# Application by Suffolk County Council for an Order Granting Development Consent for the Lake Lothing Third Crossing (Lowestoft)

## Planning Inspectorate Reference TR010023

### Acoustic Supporting Evidence on behalf of Northumbrian Water Limited

Project Ref: 42498/3002 | Date: January 2019

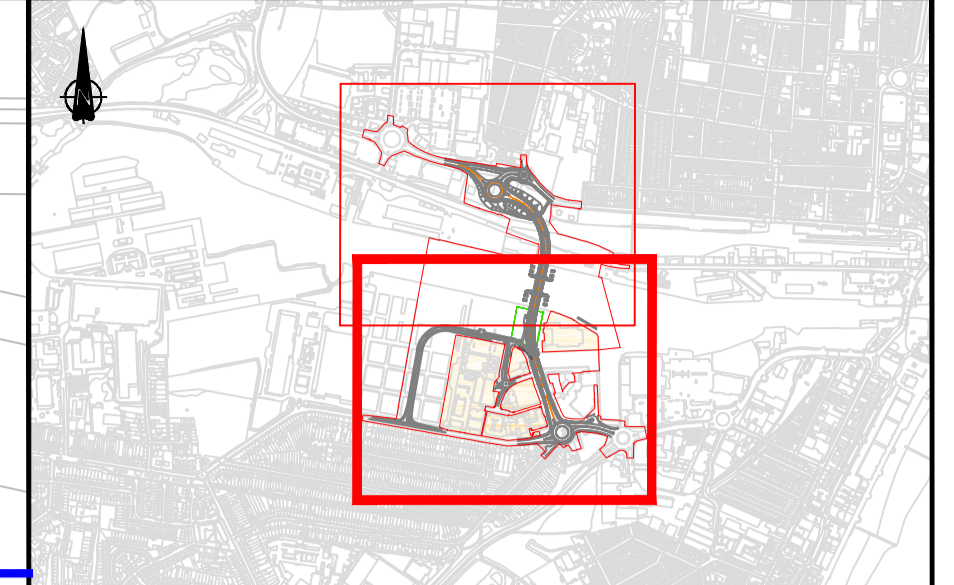
- 5.2.5 The results of the assessment suggest that internal noise levels following completion of the scheme are likely to exceed industry standard guidance levels (including BCO guidance and BS 8233 as detailed in section 2.3.5 of this report) within Trinity House. Given the sensitivity of the building to noise this may result in issues with speech intelligibility, particularly if call centre operatives raise their voices to compensate, resulting in increased activity noise levels. This may have consequential effects, such as a requirement for improved communication equipment to address this issue or additional mitigation in the form of updated glazing/cladding.

- 5.2.6 Based on the above assessment it is considered that the potential noise impact on the call centre has not been appropriately assessed and information has not been presented in a transparent manner to allow it to be interrogated by third parties. To remedy the deficiencies in the ES, the applicant should update the assessment to include full details of traffic data and a full assessment of the potential operational noise impacts on Trinity House.
